# Former Nestlé Factory

London Borough of Hillingdon Access Officer Responses

October 2017

FIGURE 3.14

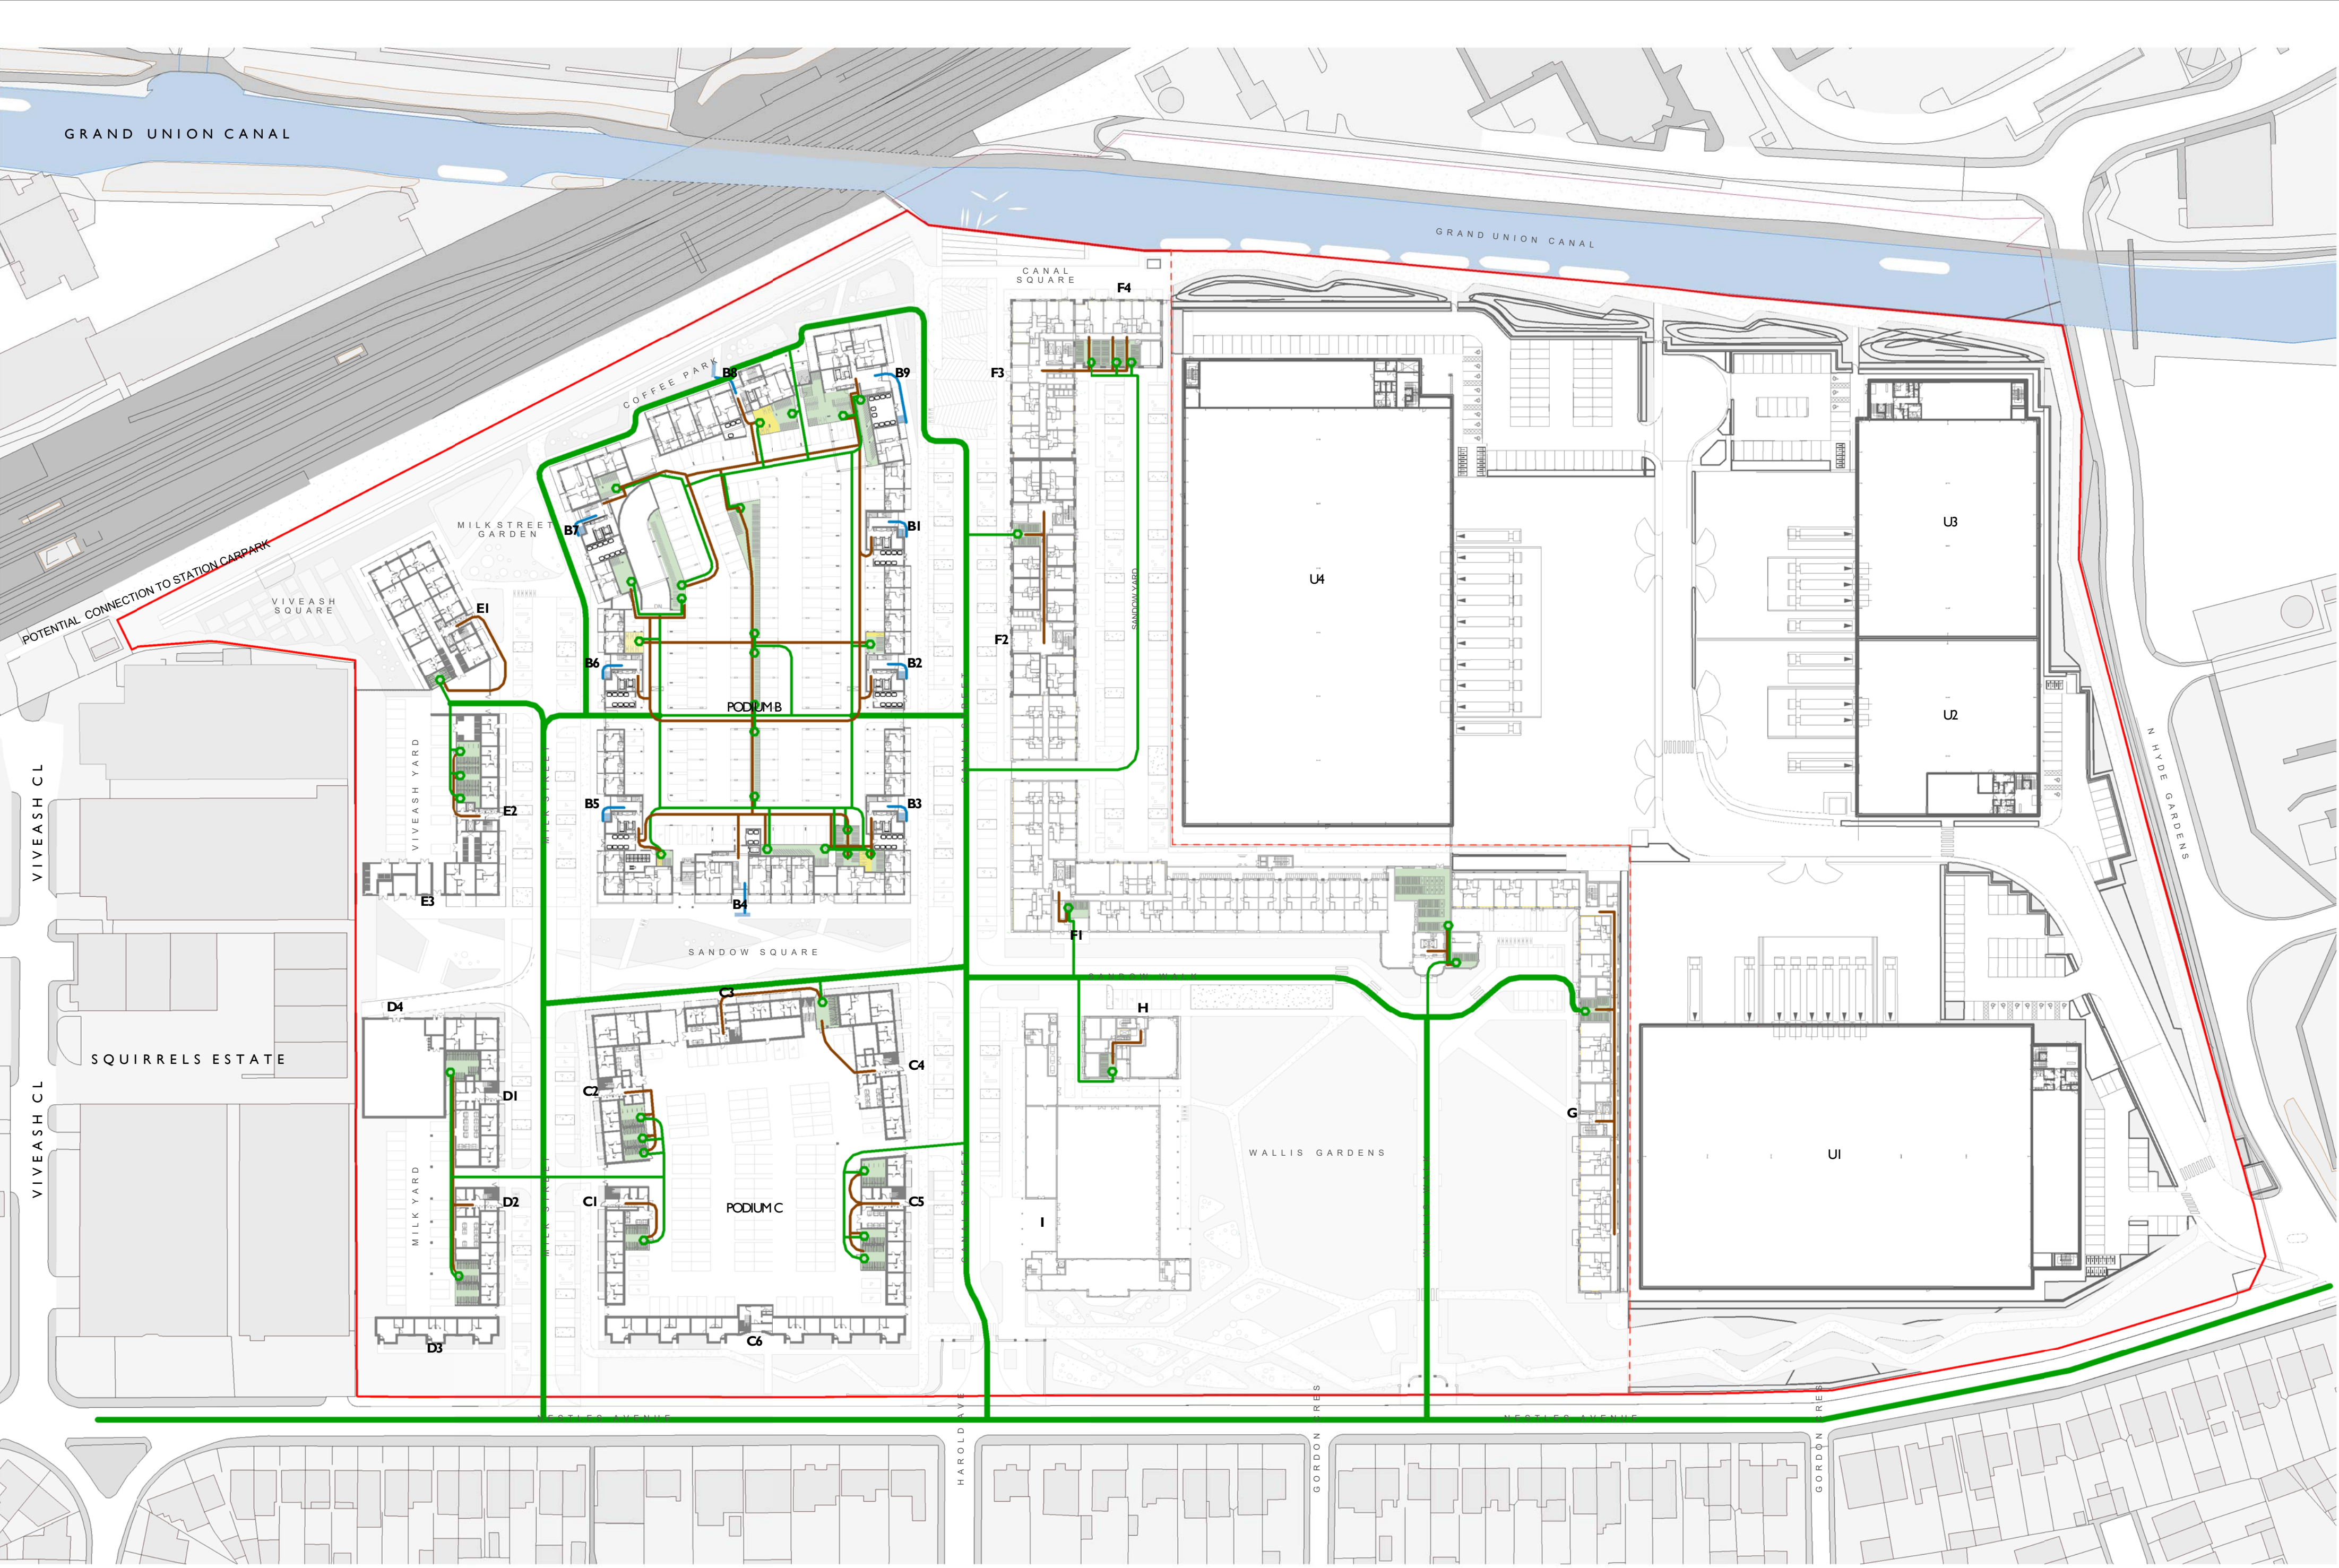
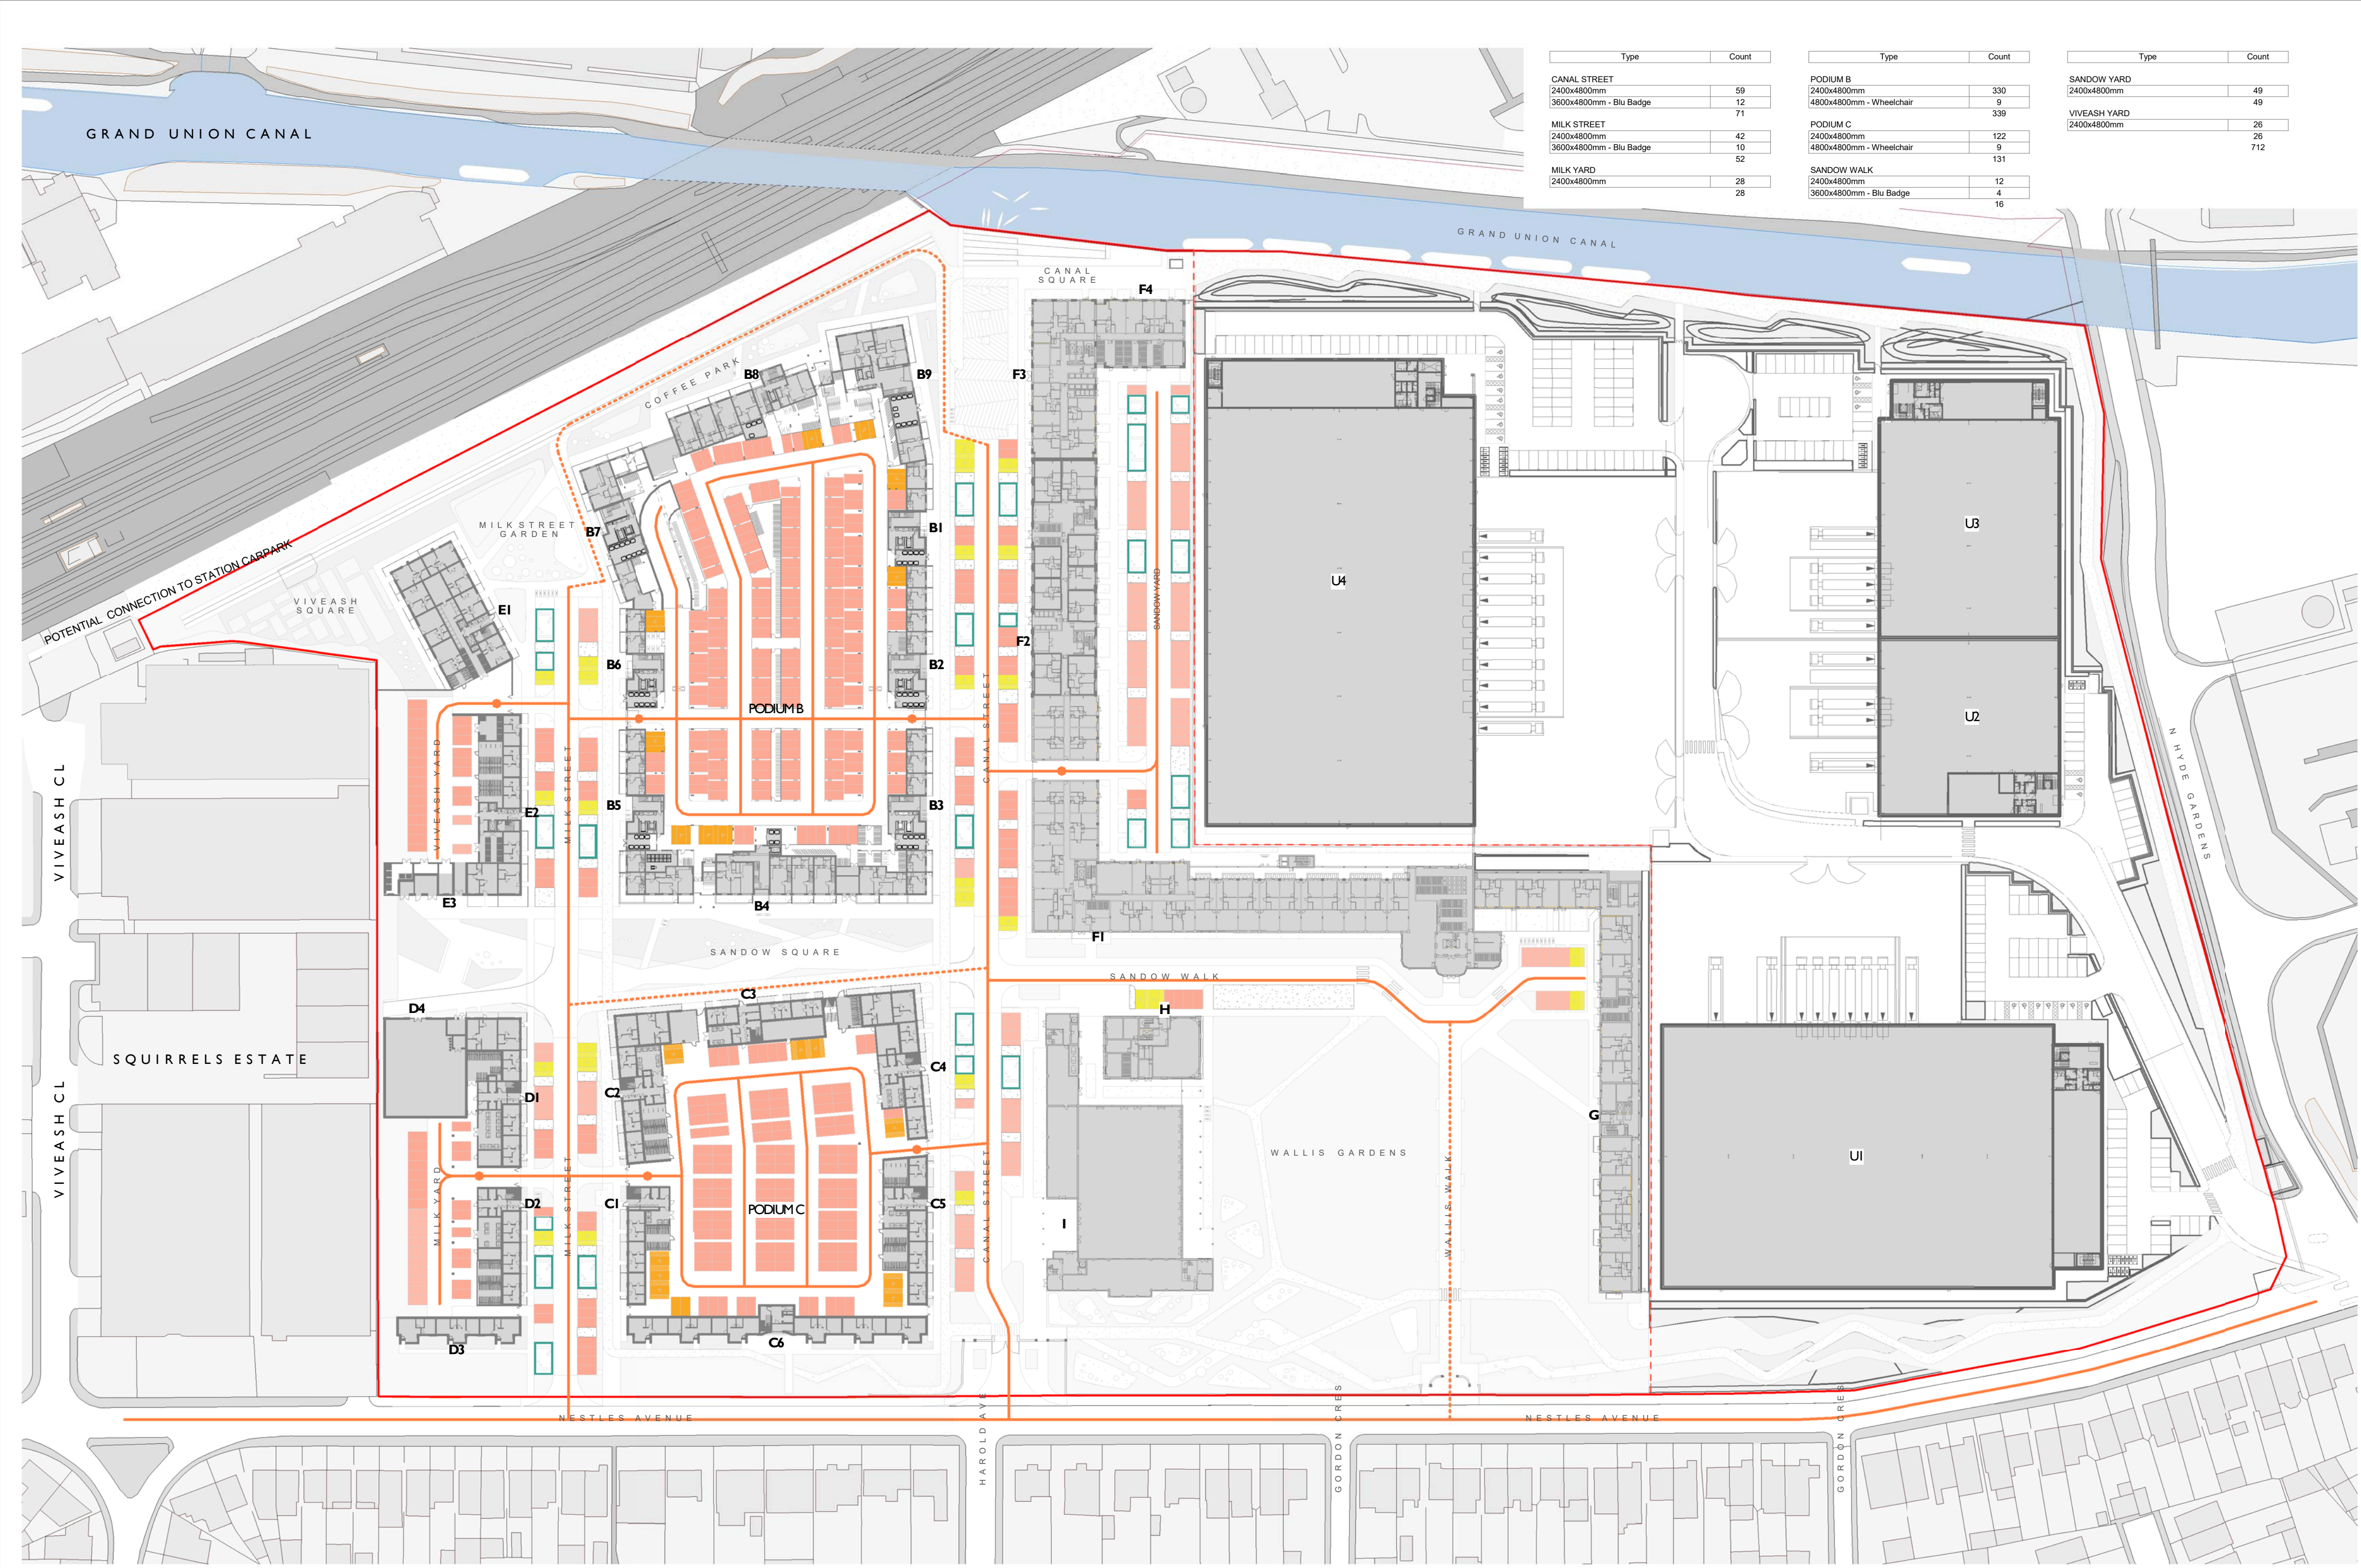
Number	Access Office comments	DBA Comments / Recommendations	Status
2	<p><b>The design of accessible parking spaces, for residents, employees and visitors, should cater for high sided vehicles with side and rear wheelchair access.</b></p>	<p>Accessible bays have been designed to comply with AD M requirements: residential accessible bays provide a 1200mm clear access zone to both sides as per AD M Volume 1; Blue Badge bays for public use provide a 1200mm clear access zone to one side and the rear as per AD M Volume 2.</p> <p>Surface parking for residential and commercial uses will be distributed throughout the development, including accessible parking bays in close proximity to all the entrances.</p> <p>Additional accessible bays for residents will be provided at GF and basement levels under the podiums in blocks B and C. Accessible bays within the covered parking will have a clearance of 2800mm above the bay and 2650mm above the circulation routes, in line with BS 8300 recommendations, to allow for high-sided vehicles.</p>
